Recommendation Report for Planning Permission

REF NO: FP/78/22/PL

LOCATION: 32 Sea Drive
Felpham
PO22 7NE

PROPOSAL: Variation of Condition following grant of FP/51/21/PL relating to Condition No 2 - approved plans.

**COLOURED
ELEVATIONS**

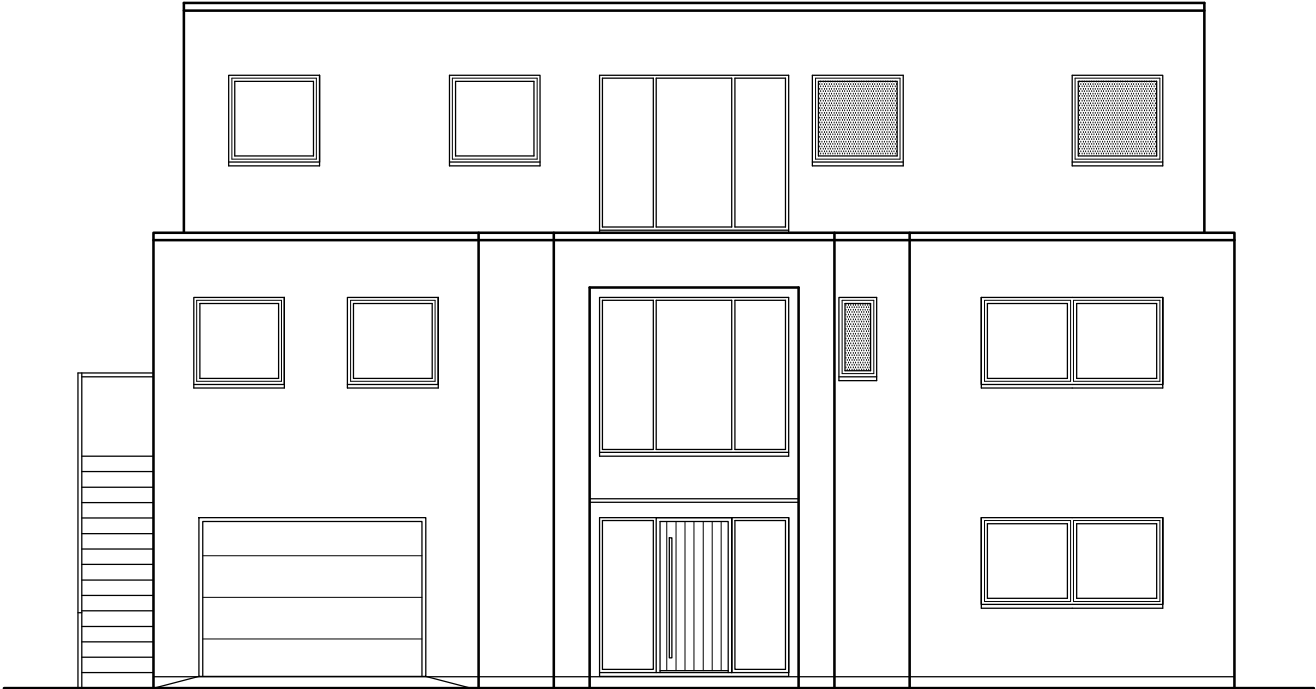
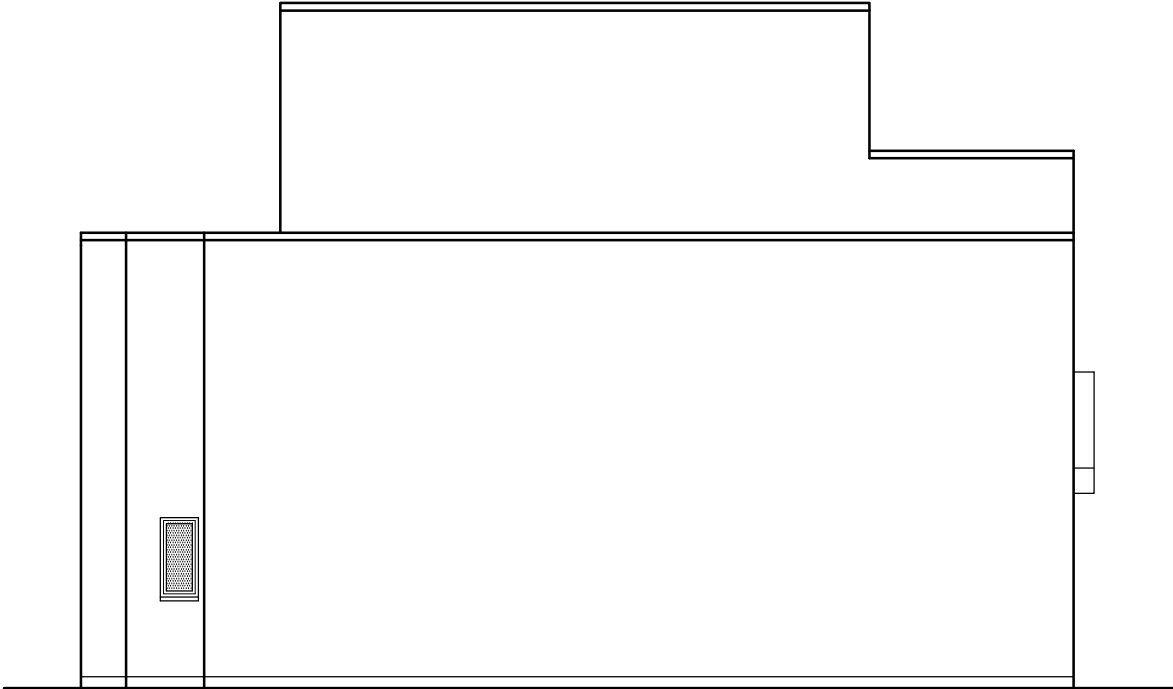
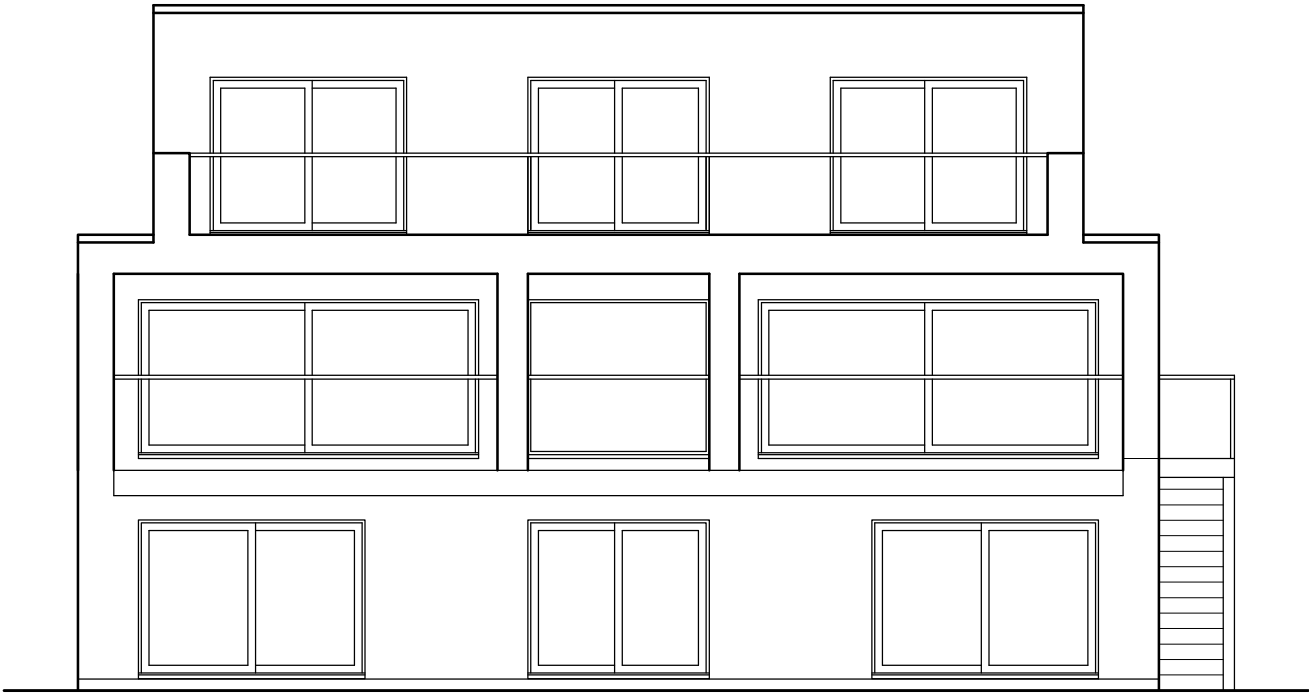
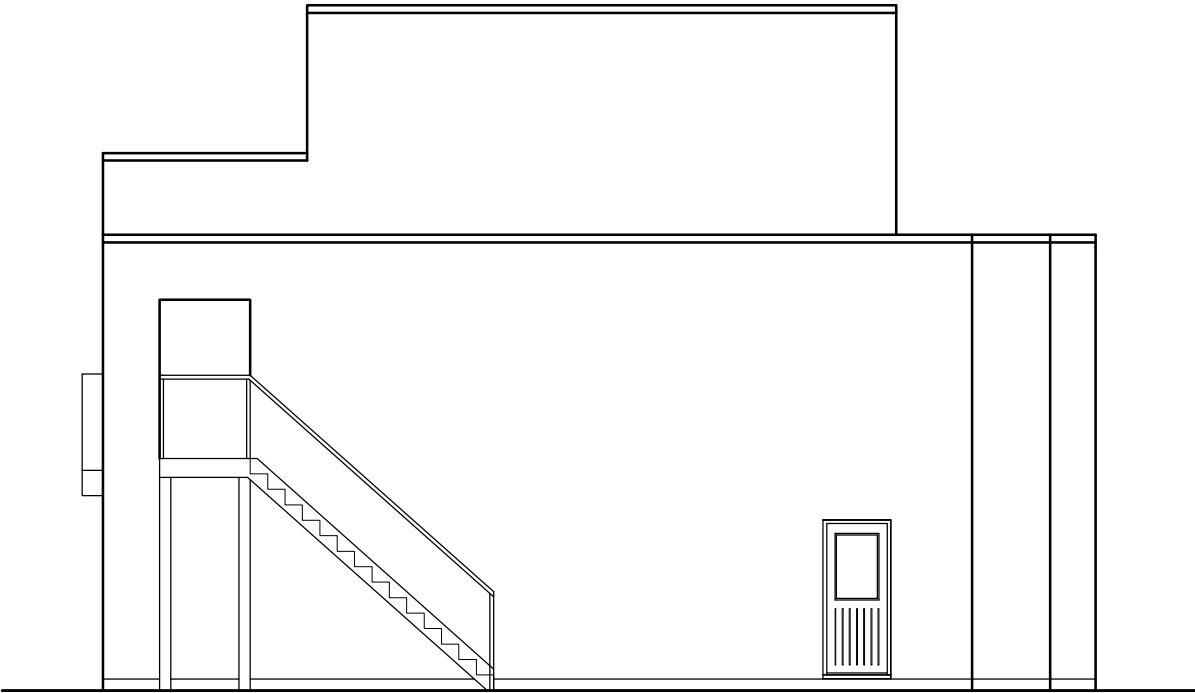
The amendments involve changes to fenestration of the dwelling. The outline of the amended front and rear elevation would be almost the same, only the third floor would be slightly narrower. The depths of side elevations would be significantly reduced (by 3m at the ground and first floor level and by 4m at the third floor). Side doors on the eastern elevation would be moved to the right, two obscure glazed windows are proposed at the ground and first floor level of the western elevation. There would be changes in the size and shape of the approved front fenestration, however the concept would be similar. the same applies for the rear elevation. The size of proposed external stairs would be similar as approved, but the design would be different.

- 13 INFORMATIVE: The ground levels in the garden are relatively low and looking at the drawing of the southern elevation it would appear that the floor levels are almost flush with the ground. It would be prudent to consider raising the floor levels slightly to prevent water ingress and improve the property's flood resilience.
